Planning Application No: 3/2025/0733

Proposal: Proposed side extension with front and rear dormer roof extensions.

Location: 41 St Marys Drive Langho BB6 8DL

PROPOSED SITE PLAN
(SCALE 1:500)

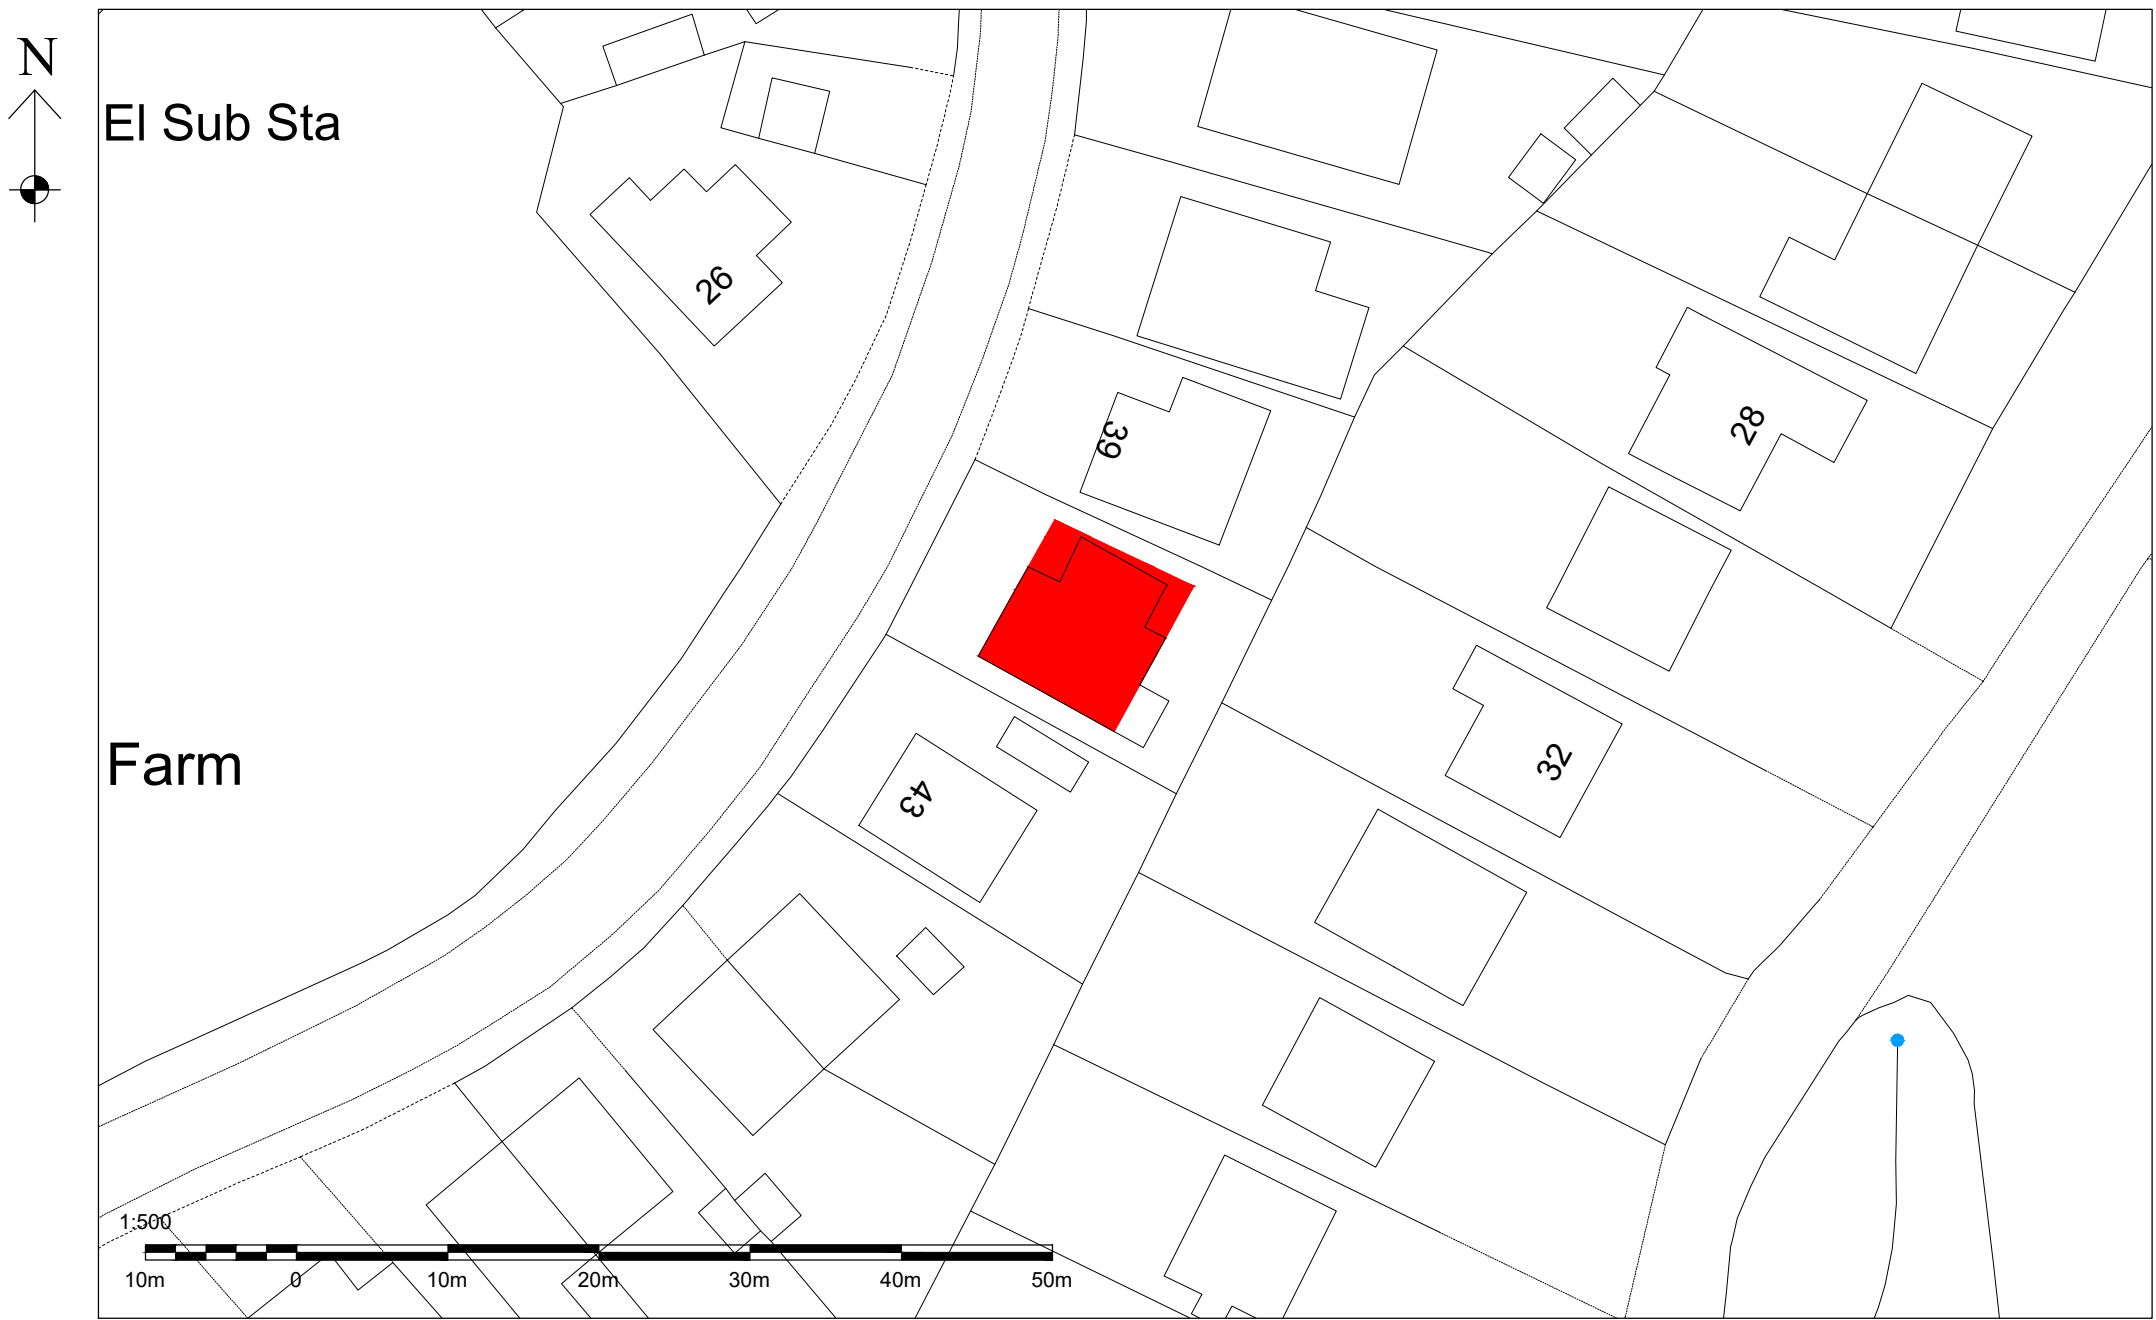
To create space for 3 off road parking spaces, as required by parking standards for this size of proposal, ref. Drawing 101 Rev C (28.7.26) Proposed Site Plan, submitted the vehicular crossing must be widen to the full width of the drive, in order to prevent damage to the footway.

- Before the access is used for vehicular purposes, that part of the access extending from the highway boundary for a minimum distance of 5 m into the site shall be appropriately paved in tarmacadam, concrete, block pavements, or other approved materials. Reason: To prevent loose surface material from being carried on to the public highway thus causing a potential source of danger to other road users.
